The Sizewell C Project

**Natural England's Response to The Examining Authority's Request
for Written Responses from Issue Specific Hearing 10**

Planning Inspectorate Reference: EN010012

17th September 2021

Plate 4.3: Indicative Delivery Routes – Isle of Grain

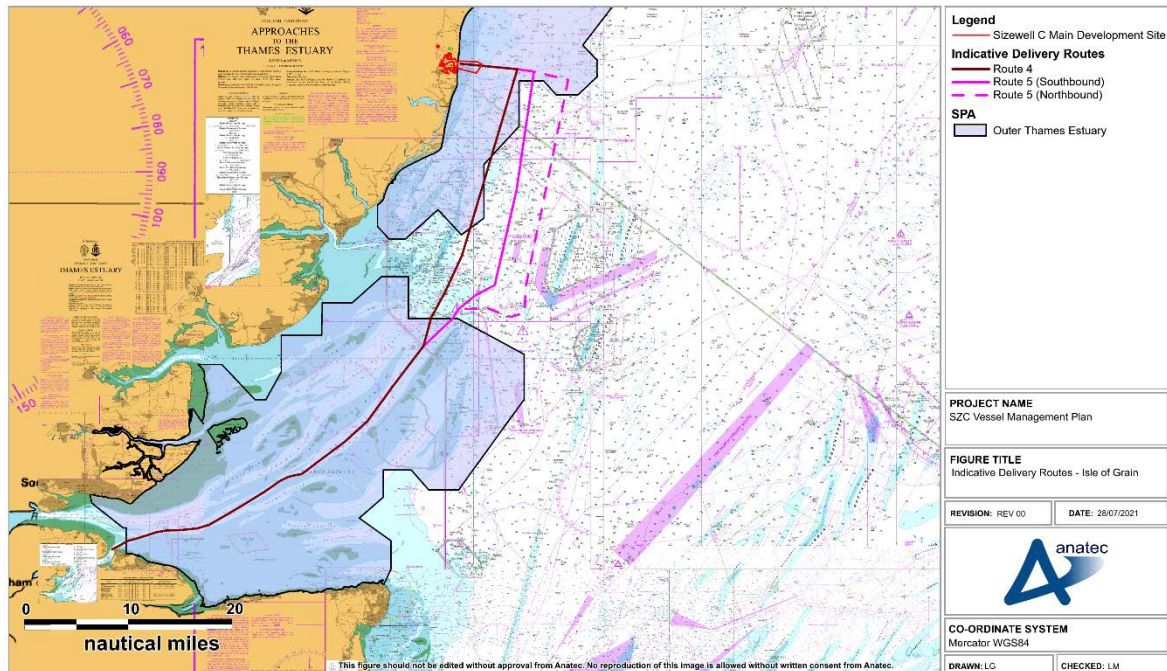
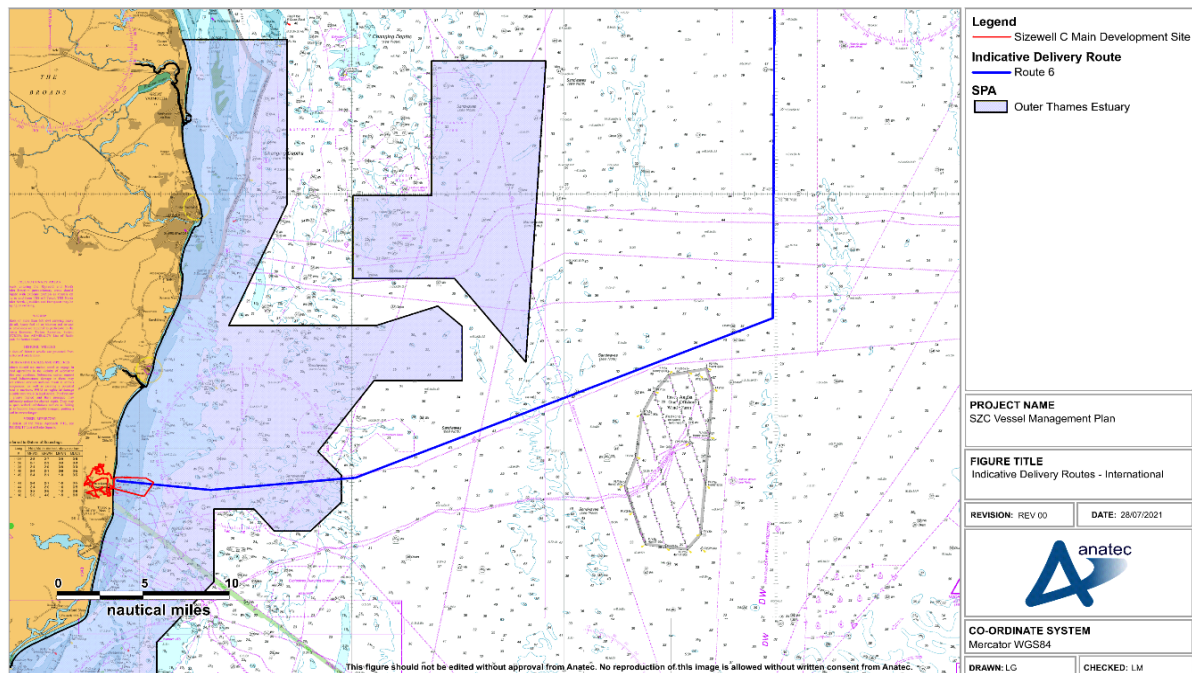
- 3.2. Natural England provided our comments on Revision 1.0 of the Applicant's Outline Vessel Management Plan at Examination Deadline 7 (dated 3rd September 2021, our ref: 366560) [REP7-141] which highlighted concerns around the routes put forward in the plan, and the inadequacy of the proposed monitoring. In light of this, we still cannot rule out an AEol based on the information provided
- 3.3. We are currently reviewing Revision 2.0 of the Outline Vessel Management Plan, submitted by the Applicant at Deadline 7 [REP7-046&047], and will provide our comment on this version to the examination at Deadline 8.
